WALBERTON PARISH COUNCIL

**Planning Application WA/56/09 – 9 Hunters Mews, Fontwell
Move garden wall 5m further east**

Scale 1:500

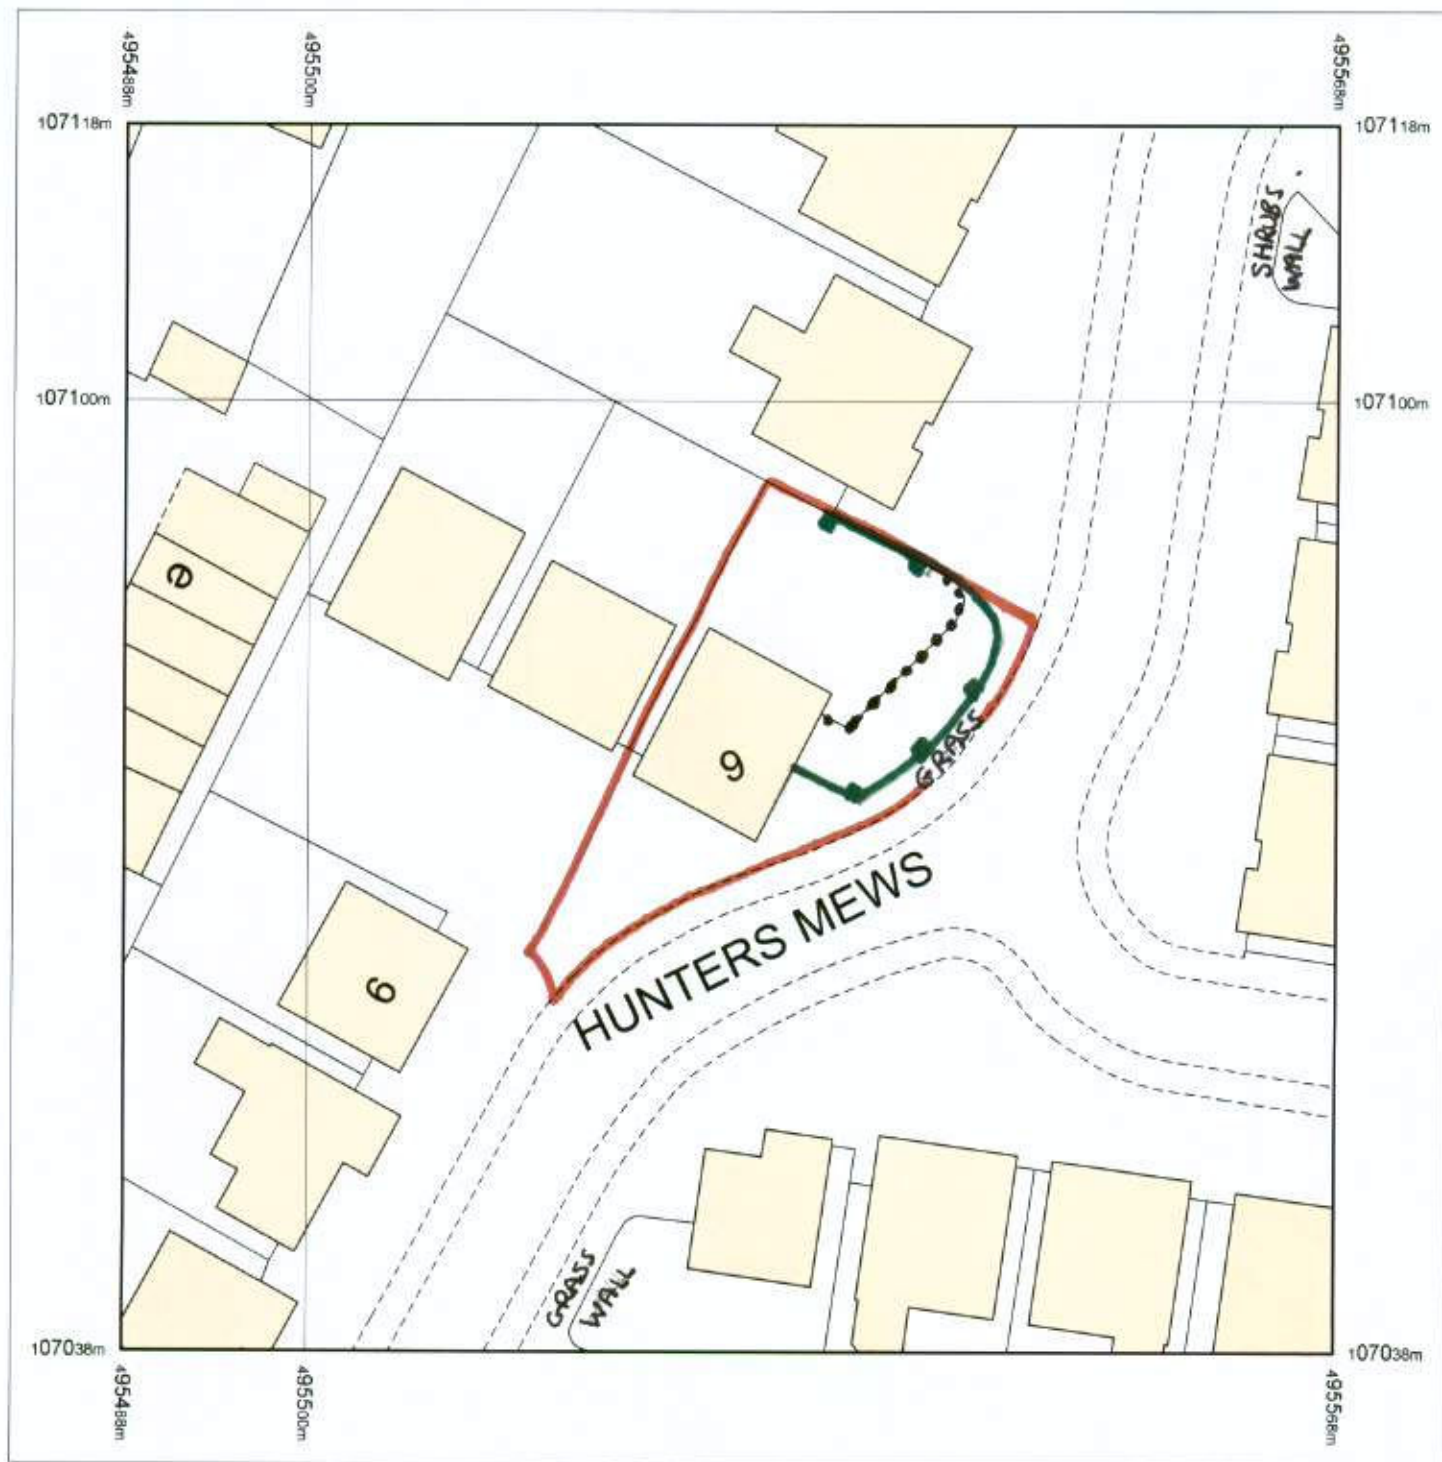
Hunters Mews is characterised by a generally open aspect at the front of the properties with grass lawns and verges. The Council feels that moving the wall right up against the pavement at this prominent location would intrude into that open space and adversely affect the street scene. It would also create an unwelcome precedent that could lead to harsh enclosures throughout the development.

Additionally, there is currently a good field of view through this section of the development which would be blocked by the proposed wall to the possible detriment of pedestrian and driver safety.

(Contrary to Arun District Local Plan Gen 7)
